GRADIENTWIND

August 17, 2022

Re: Pedestrian Level Wind Study Addendum
2046, 2050 Scott Street and
295, 299, and 301 Ashton Avenue, Ottawa
Gradient Wind File 19-246

FIGURE 5: SUMMER – % OF TIME SUITABLE FOR SITTING WITHIN AMENITY TERRACE (LEVEL 6)

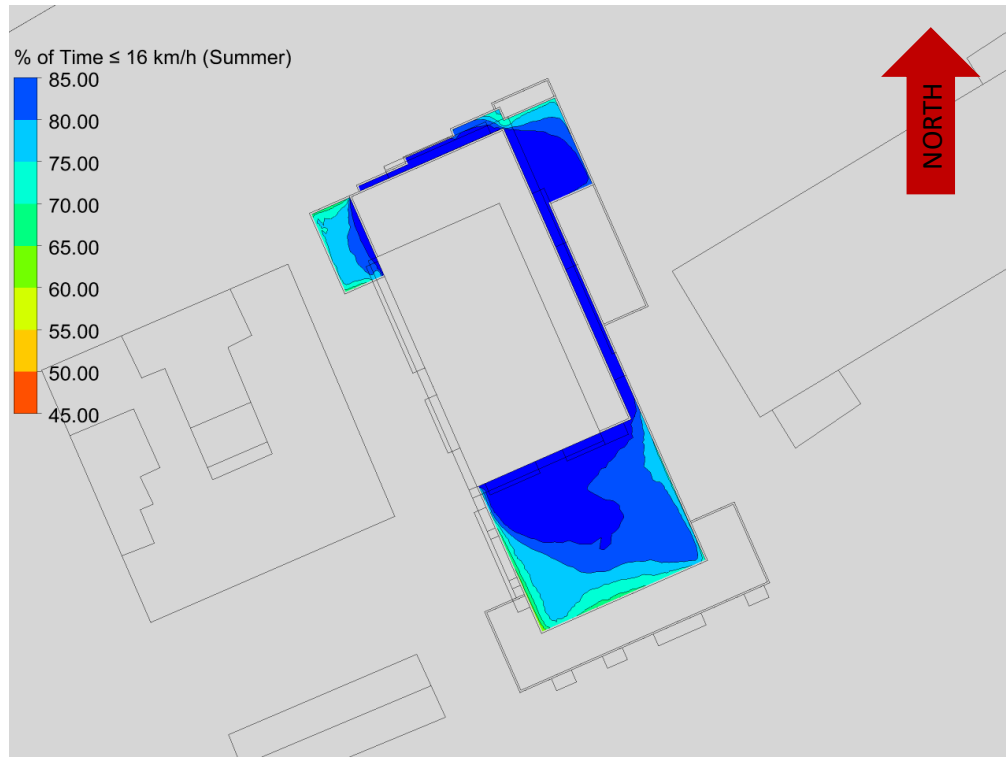
"The wind study's summary states that "wind conditions within the common amenity terraces at Level 6 are predicted to be suitable for a mix of sitting and standing during the summer with most areas predicted to be acceptable for sitting at least 70% of the time during the warmer month of the year." The City's Wind Analysis Terms of Reference state that "the criterion has been met if the wind speeds occur at least 80% of the time or four out of five days."

The PLW study identified several areas within the common amenity terrace serving the proposed development at Level 6 that are predicted to be suitable for sitting for at least 80% of the time during the summer season. The landscape design³ for the amenity terrace was developed to take advantage of the calm areas. Specifically, the landscape design includes seating and lounging areas to the south of the

tower (within the east half of the roof), to the east of the tower, as well as to the northeast of the tower. No further action is recommended with respect to pedestrian wind comfort for the common amenity terrace serving the proposed development at Level 6.
